Appeal Decision

Appeal Ref: 6011782

25 Stirling Road, Hayes, Hillingdon UB3 3AH

PROPOSED GROUND FLOOR PLAN

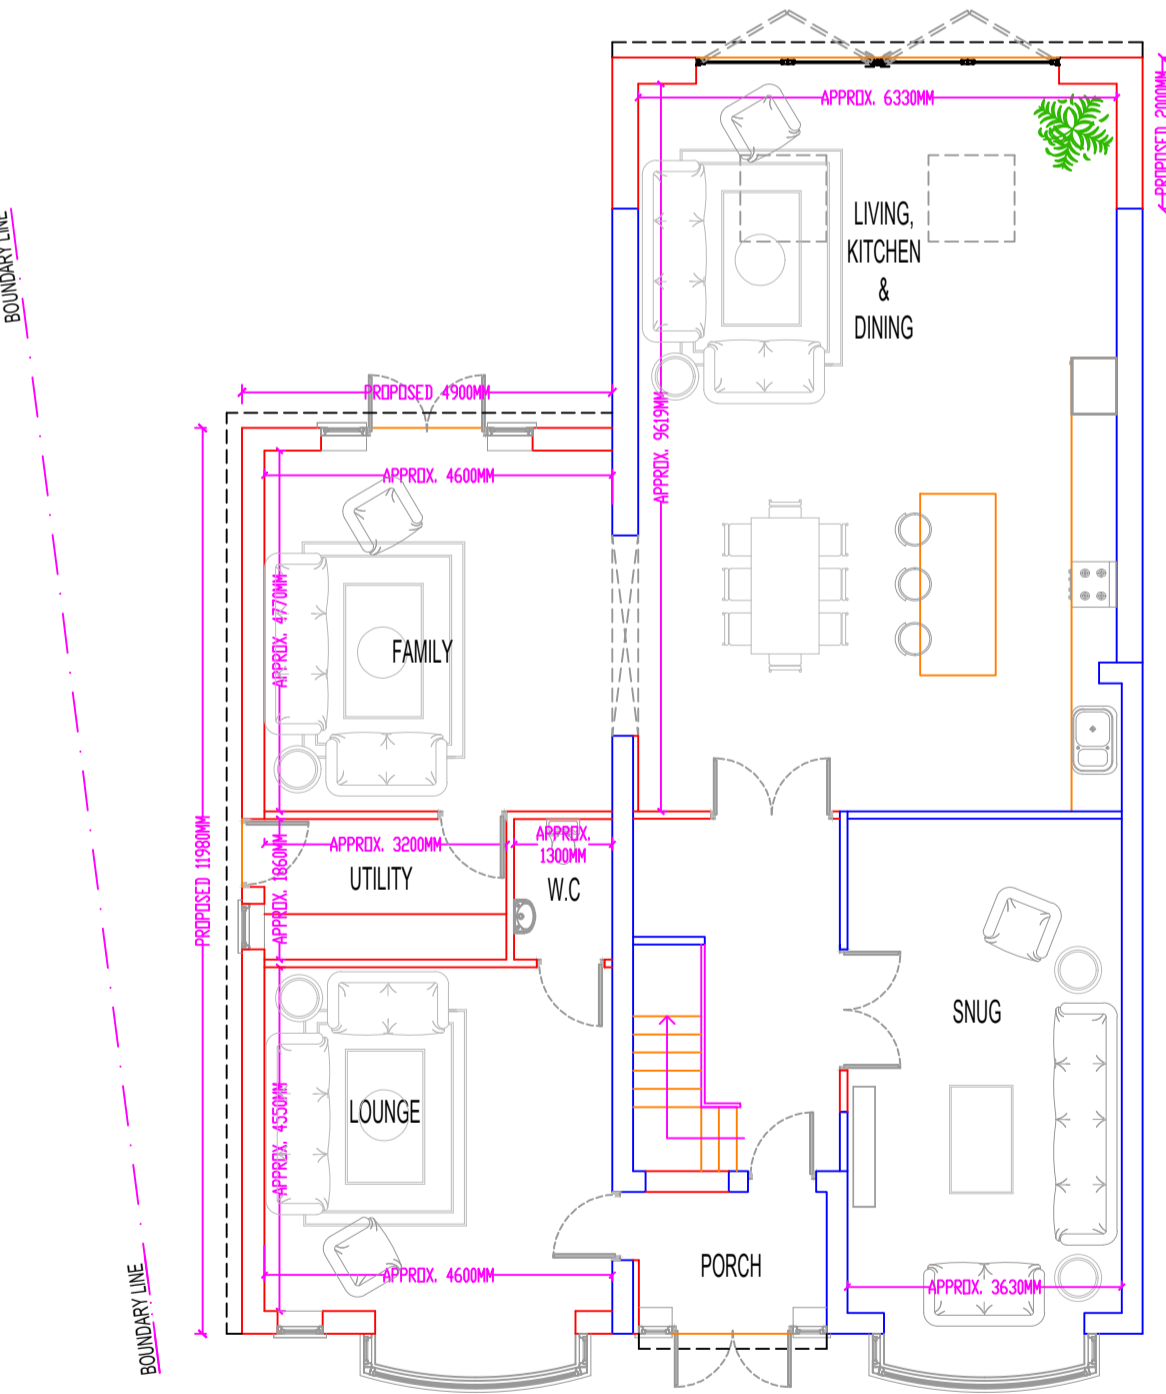
9. The proposal also includes a single storey rear extension that would lengthen a rear addition that has recently been permitted. LP Plan Part 2 Policy DMHD 1 states that single-storey rear extensions to detached houses on plots at least 5 metres wide should not exceed 4 metres in depth. Whether or not the proposal would exceed this threshold, the supporting text to this policy establishes a presumption against further extensions to existing extensions.

PROPOSED ROOF PLAN

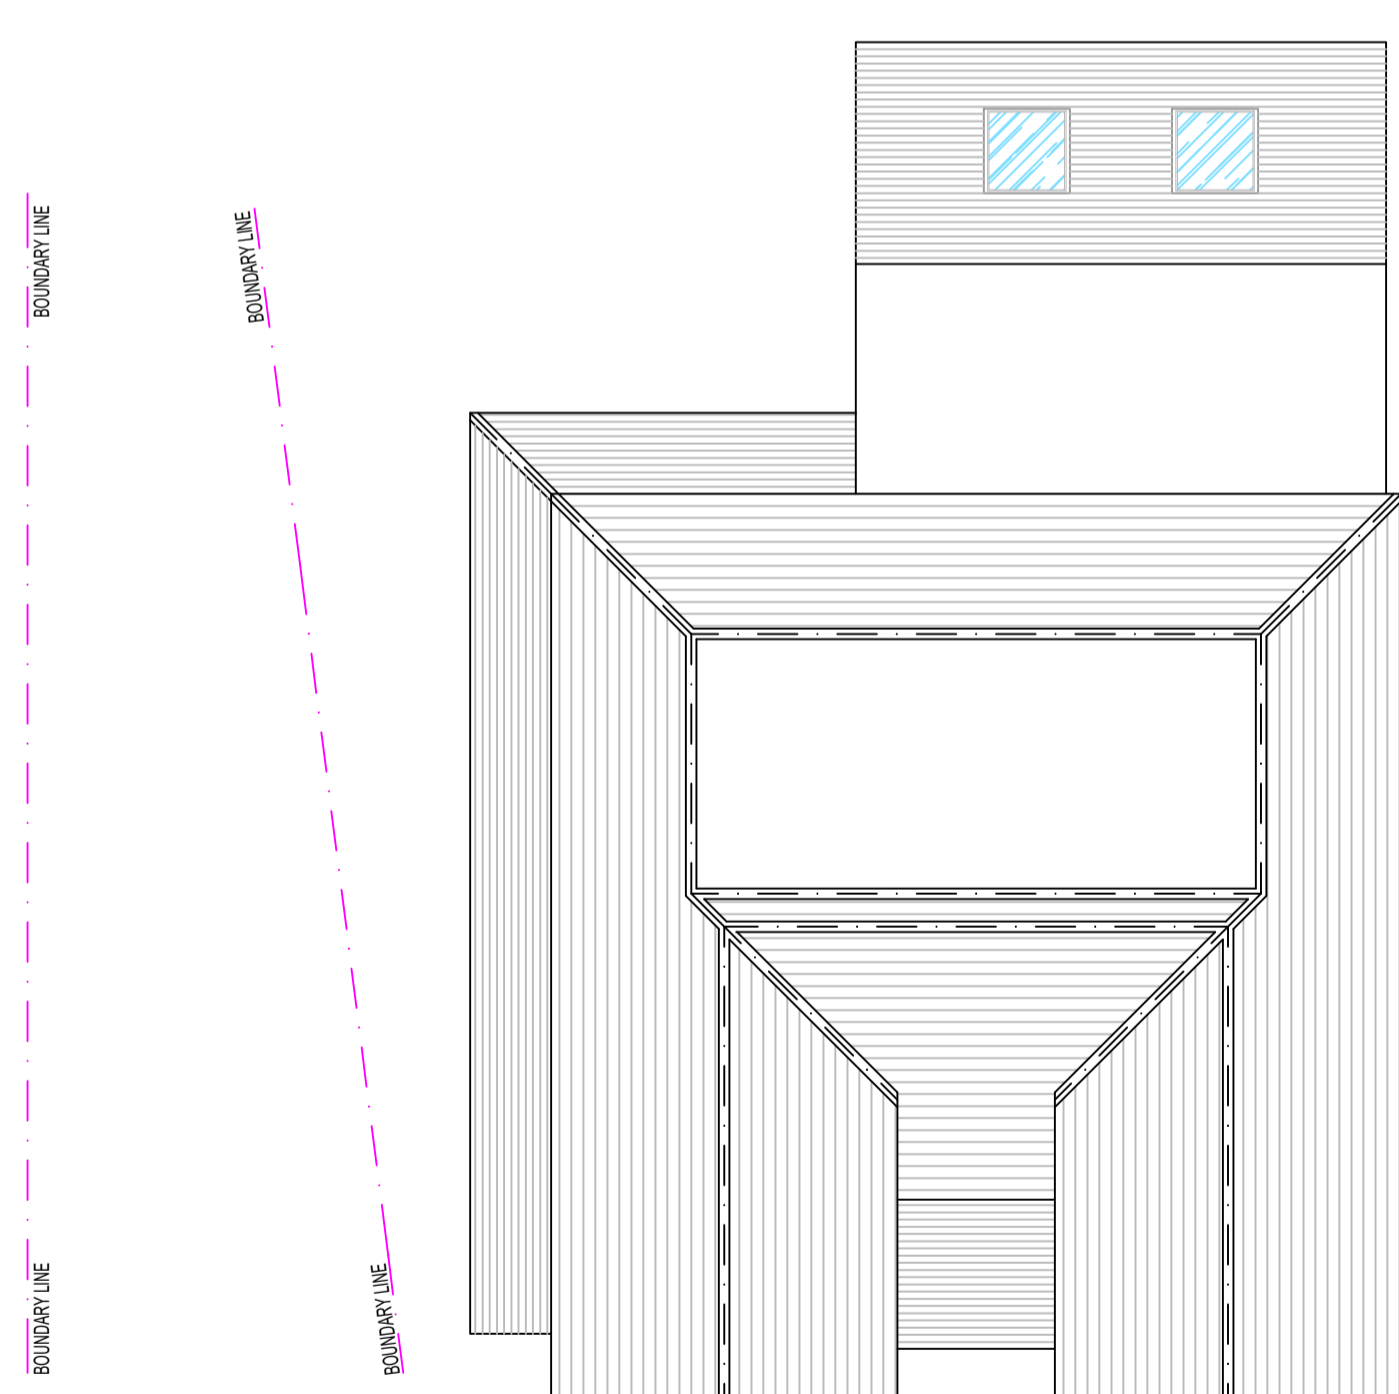
8. The proposed roof would be no taller than the existing ridge and the flat central section would be largely concealed when viewed from ground level by the adjacent roof slopes. The adjoining two-storey houses would also limit views of its scale and depth to short sections of Stirling Road. However, the considerable scale of the new roof could not reasonably be described as subservient to that of the existing roof, nor would it be confined to the rear roof only. Both are requirements of roof extensions under LP Part 2 Policy DMHD 1. Furthermore, the enlarged roof would contribute to the substantial increase in the dwelling's scale and bulk.

PROPOSED FRONT ELEVATION

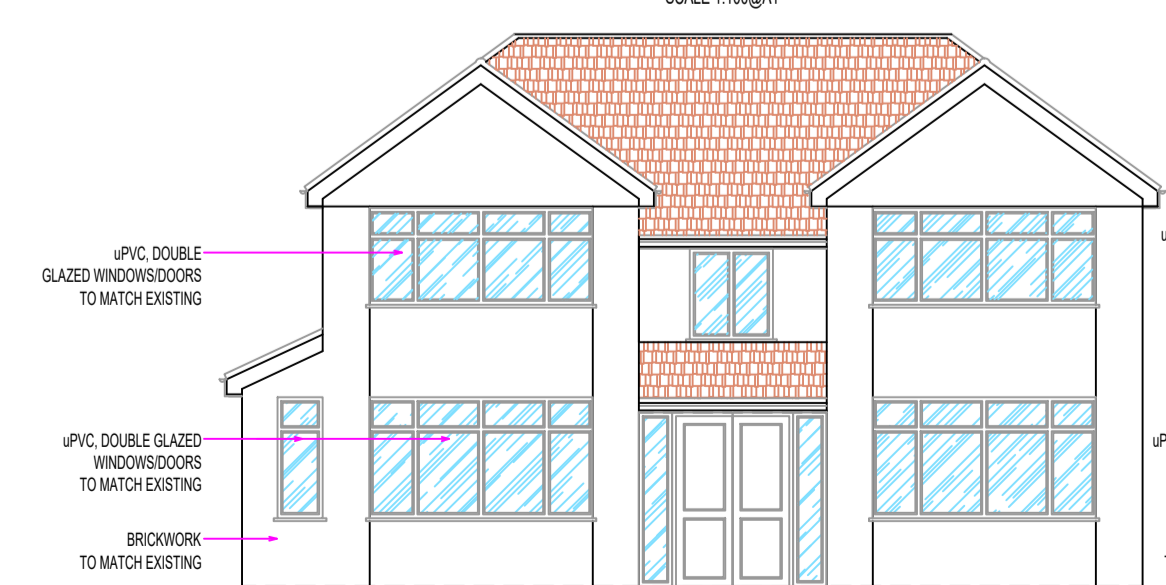
6. The proposal is to substantially enlarge the dwelling with sizeable extensions on three sides and alterations to its roof form. The additional two-storey front gable, extensive side and rear enlargements and broad crown roof would significantly change the scale, proportions and architectural composition of the existing house.

7. That the central porch would be flanked by front gables would introduce some general symmetry to the principal elevation. Matching external materials would also provide a degree of visual cohesion to the appearance of the scheme. However, these features would not overcome the substantial increase in the dwelling's scale and bulk that is proposed. Furthermore, the new side extension would not be appreciably set back or set down from the main house and it would not read as a subordinate addition. These are specific requirements of Policy DMHD 1 of the Hillingdon Local Plan Part 2: Development Management Policies (LP Part 2), with which the proposal would conflict.

PROPOSED SIDE ELEVATION

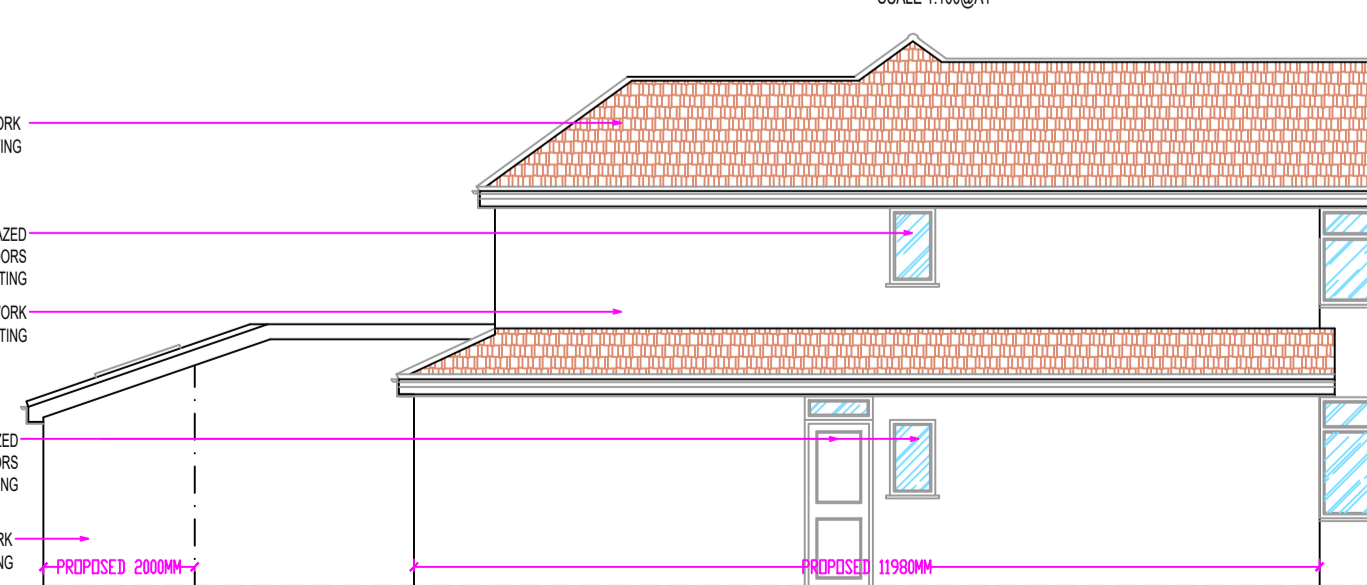
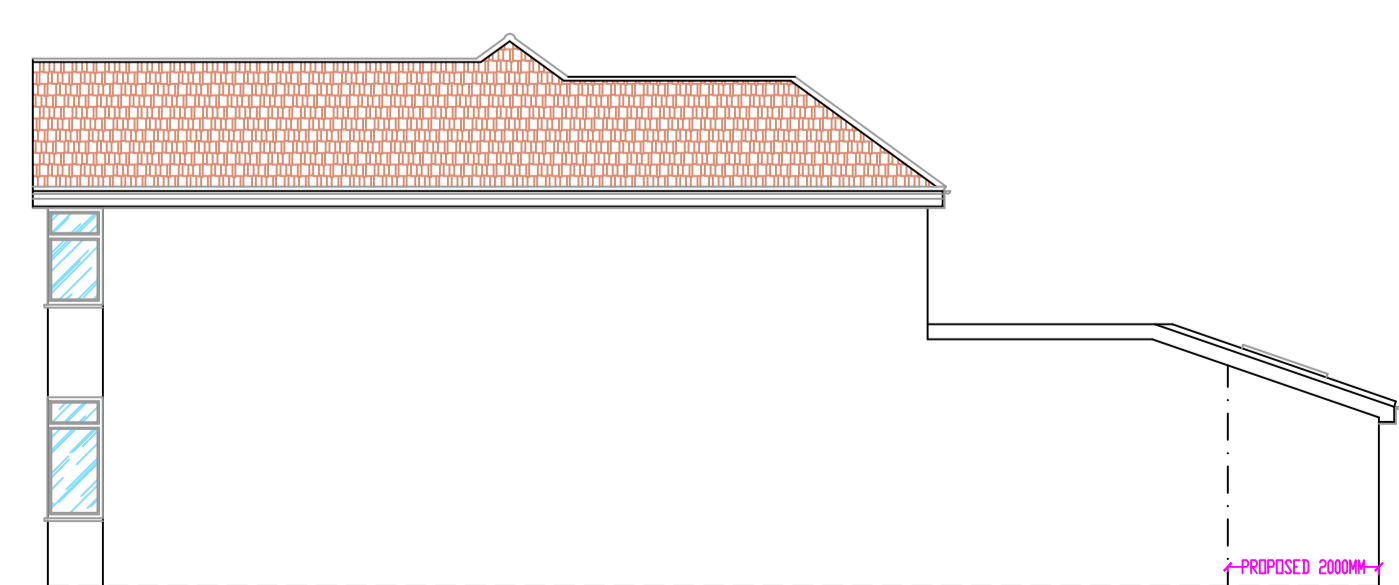
13. On the main issue, I conclude that the proposed development would harm the character and appearance of the host dwelling by overwhelming its design and proportions and by failing to maintain a subordinate relationship between the

extensions and the existing building. Notwithstanding the architectural variety along Stirling Road, the resulting size and bulk would also make the dwelling appear overly dominant and obtrusive within the street scene, to the detriment of the character and appearance of the local area.
